Landscape & Visual Technical Briefing Note

Saltbox, Bognor Regis

Landscape and Visual Consideration of Proposed Topsoil Stock-pile

(Planning Application Reference: BE/27/20/PL)

TOP SOIL RELOCATION  
 SITE PLAN  
 1744-TS-P02-E

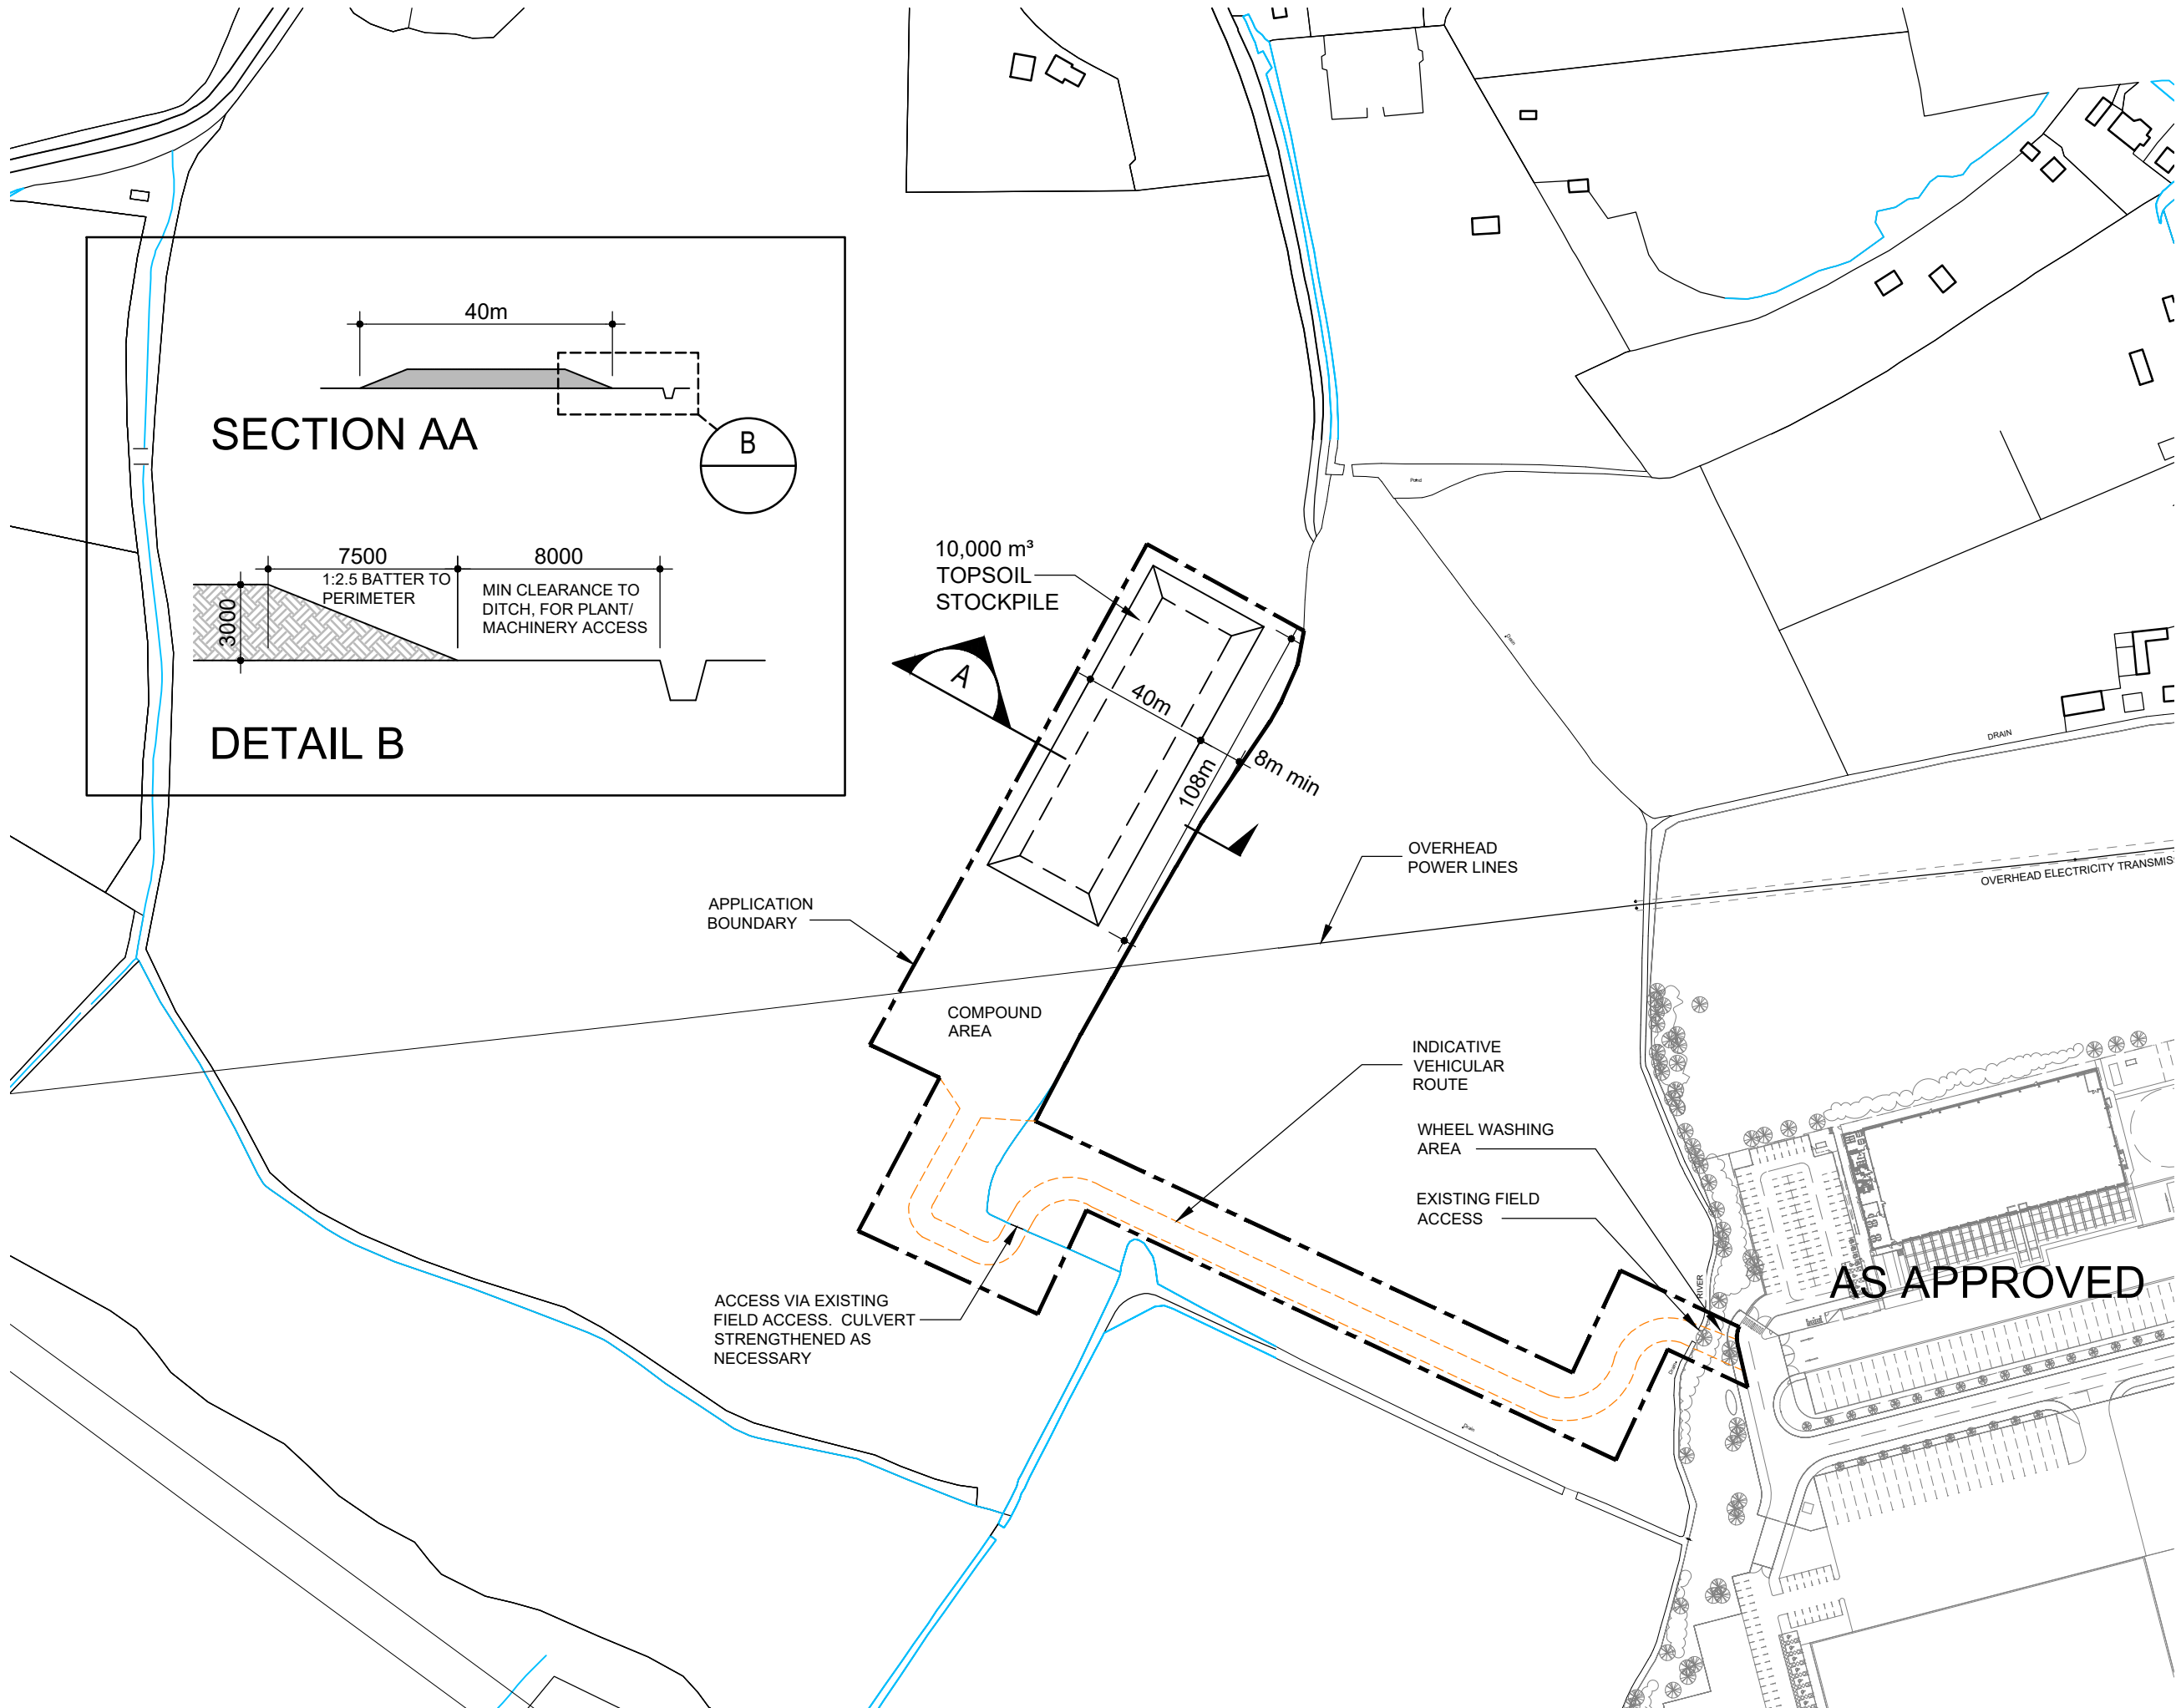
"1. The applicant should provide us with a revised Landscape and Visual Technical Briefing Note that confirms; the route of heavy plant across the site and around the stockpile, full extent of extended 8metre exclusion zone, extent of hedgerow removal at field access points; so that we can be confident retained on/off-site trees and hedgerow will not be negatively impacted throughout development. On receipt of a suitably revised LVTBN, it will need to be included in a condition forming part of any APPROVAL.

- 3.2. The topsoil stockpile will be set back from the adjacent field boundary and ditch by an 8m 'exclusion zone,' as illustrated within the enclosed 'Proposed Topsoil Relocation Site Plan' (refer Appendix 2) which will be clearly set out on site and prevent the access of any plant machinery, ensuring that the existing watercourse and boundary vegetation is unharmed. The

- 3.5. The proposals are fully illustrated within Appendix 2 and have been updated as requested, to illustrate an 8m 'exclusion zone' that is now clearly defined in order to protect the existing boundary watercourse and vegetation structure that is adjacent to the proposed stockpile and proposed vehicular route that will be used to transport the topsoil.
